Application No: R/108/21/PL  
Site Address: 117 Sea Lane Rustington BN16 2RU  
Description of works: Demolition of two dwellings and the construction of 3 No. 3-bed town houses and 7 flats. This site is in CIL Zone 4 and is CIL Liable as new dwellings.

Thank you for your internet representation made on 11th June 2021 which has been recorded as an objection with the comments as follows:

DRAWING TITLE 3D Views

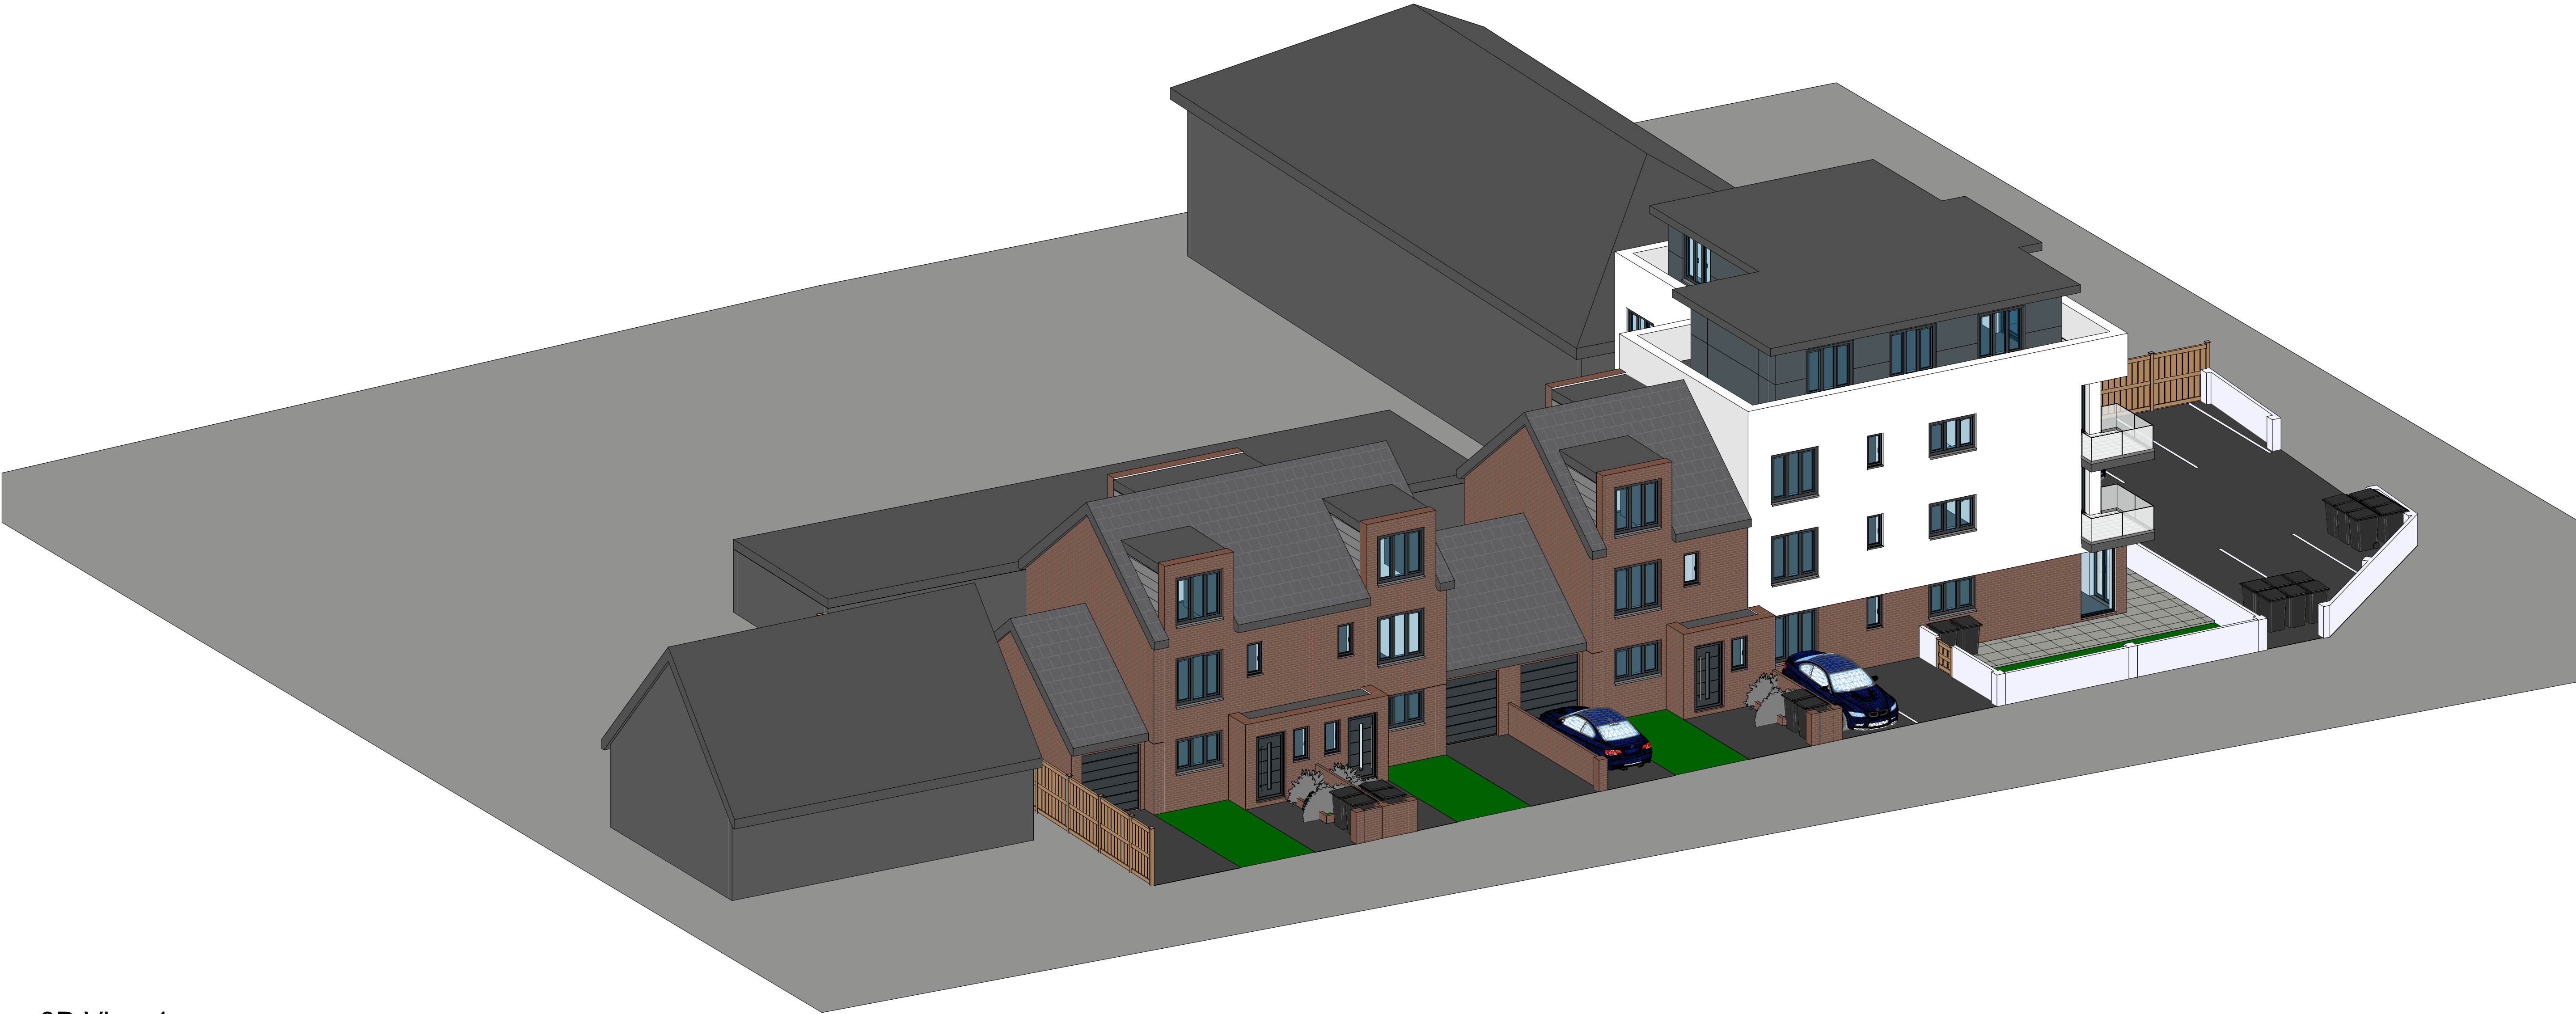
Height of the flats is 2 storeys greater than dwellings between the village shops and Overstrand Estate. The 4 storey flats will take out considerable sky-line plus daylight or sunshine, especially in the winter months. Scale/Mass of the flats (5.18) Does not reflect Rawson Court or the surrounding land/parking. Mass is mass, whatever design or colour. In this area there are no flats which are 4 storey or 3 storey with rooms in the roof.

The Town Houses: The style needs to be sympathetic to the locality where dormer windows are pitched not

squared - modern does not equal flat/squared dormer. (5.22)

The front of my home 115 Sea Lane and the totality of my garden will be overlooked by the majority of the proposed flats. In particular the two balconies and the kitchens of 3 flats where the sinks are in direct sight line with the bedrooms, lounges and gardens of 115 Sea Lane and 3-5 Shaftesbury Road. A kitchen sink is a high use area in all homes throughout the day. The kitchen sinks need to be re-sited. Existing properties will need to obscure most windows which will deny beneficial daylight to owners. Balconies also have a direct view onto existing properties and gardens. These features have a clear adverse effect on existing properties.
